**Cory Decarbonisation Project**

**Planning Inspectorate Reference: EN010128**

**SAVE CROSSNESS NATURE RESERVE**

**Deadline 4 Submission**

Sequential View 1: From England Coast Path, National Cycle Network Route 1, and the junction of Public Right of Way FP2 and FP3 – Viewing Platform, looking south-east

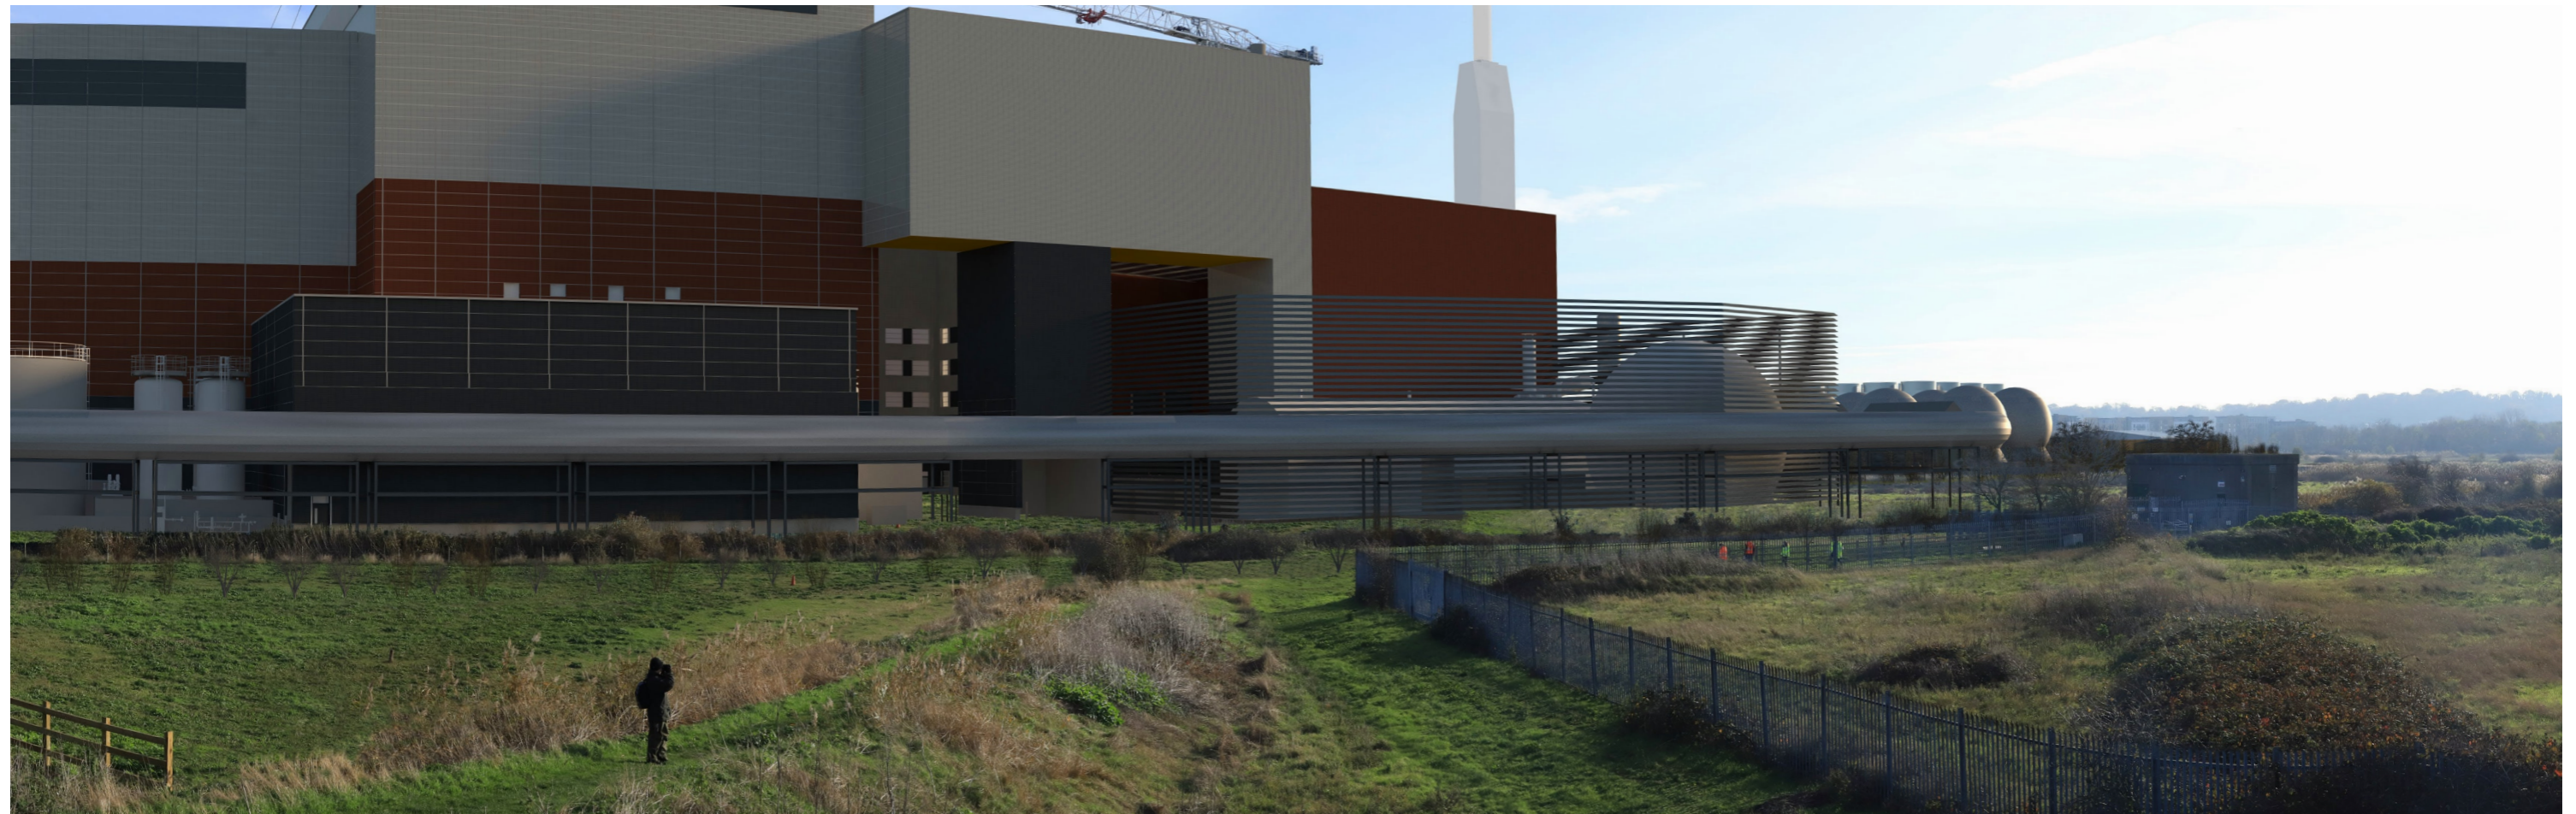
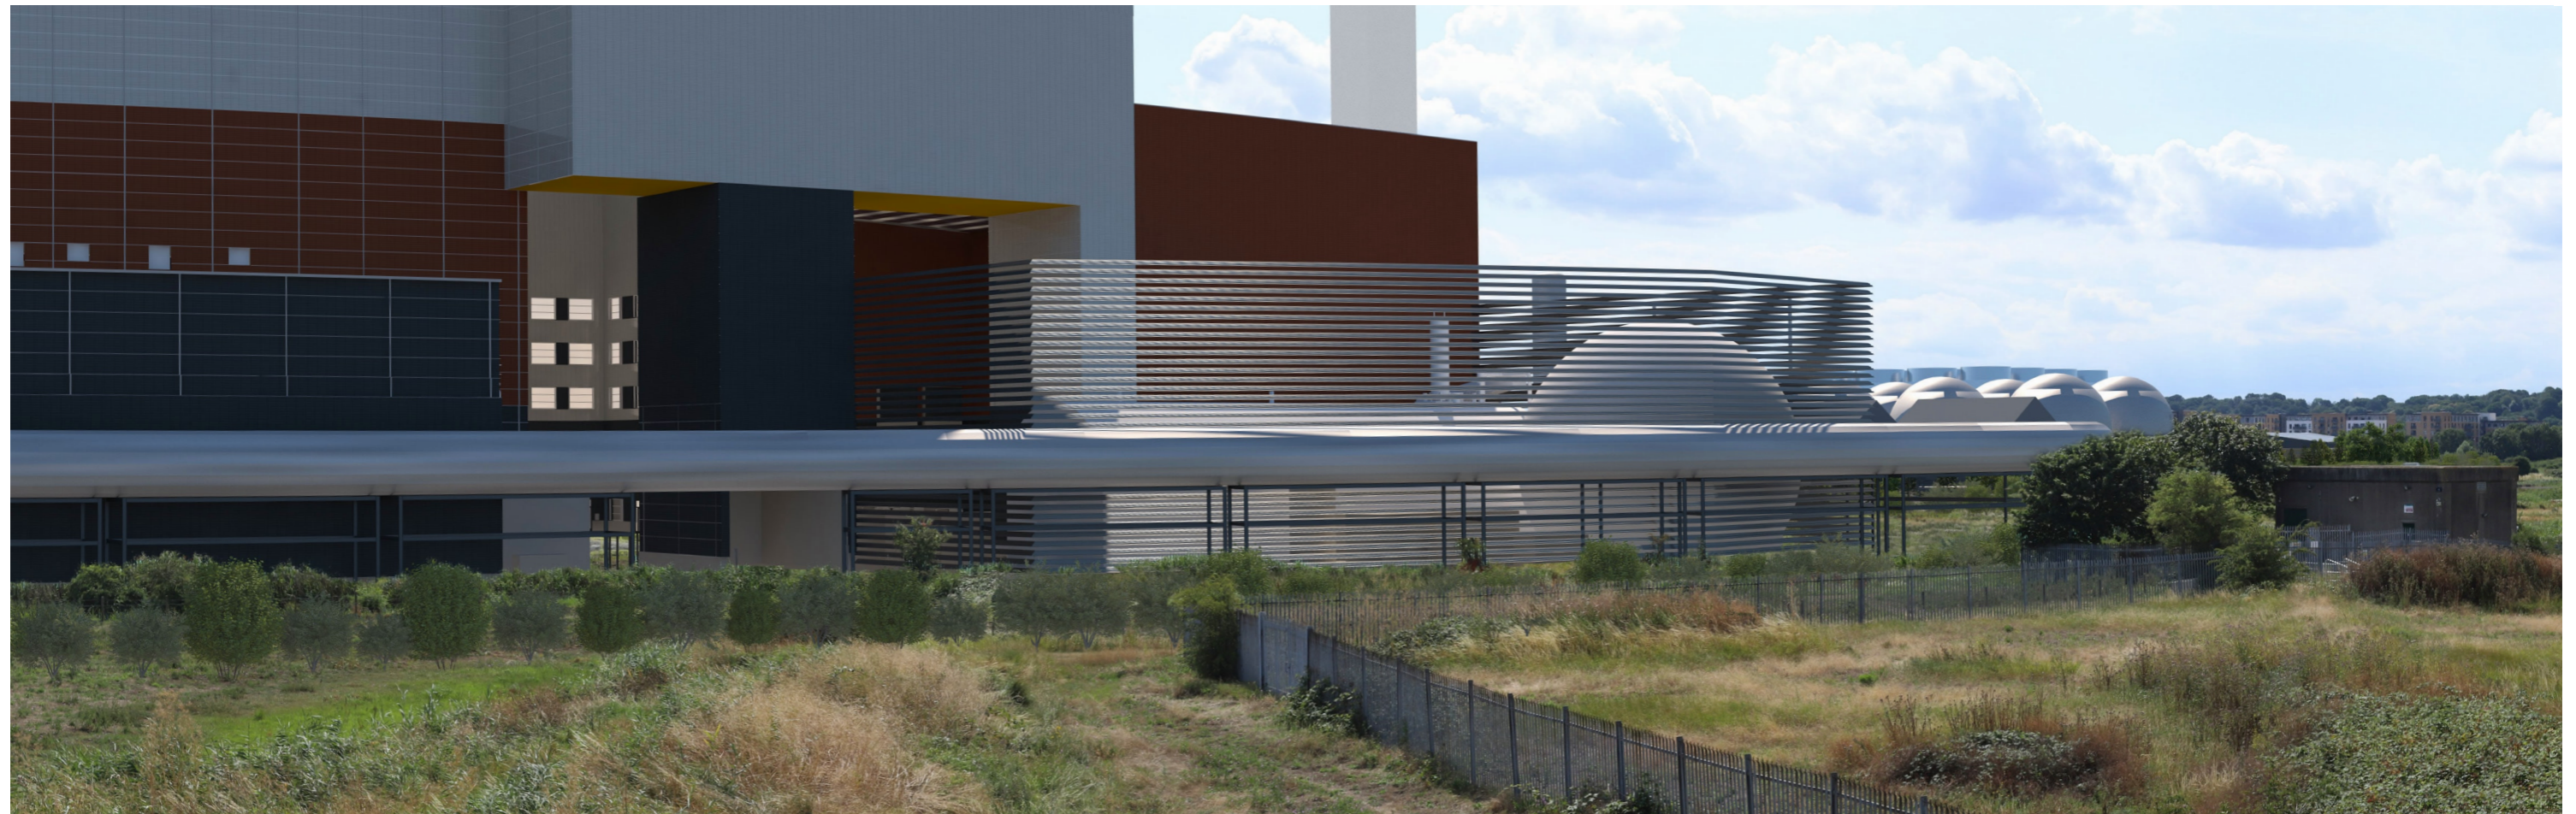
8. As raised during the Accompanied Site Visit, we are concerned that the Photomontages do not depict the full visual impact on Crossness Nature Reserve. There is no view showing the full north-south stretch of the Proposed Scheme from Crossness Nature Reserve. 'Sequential View 1' is largely obscured by Riverside 2. 'View 1' shows the Proposed Scheme from FP2 looking north, where the impact is less severe: REP1 and REP2 are already in the sightline, and you do not see the cross-section of the full north-south length of the Proposed Scheme.

9. We request that the Applicant provide an additional view from the entrance to the Member's Area (at the end of the access road and along the north-south path along the western edge of the main Crossness Nature Reserve area), so that the visual impact of the full north-south length of the Proposed Scheme can be assessed. This would also give a close representation of the view from the bird hide, which is particularly sensitive to visual impact.
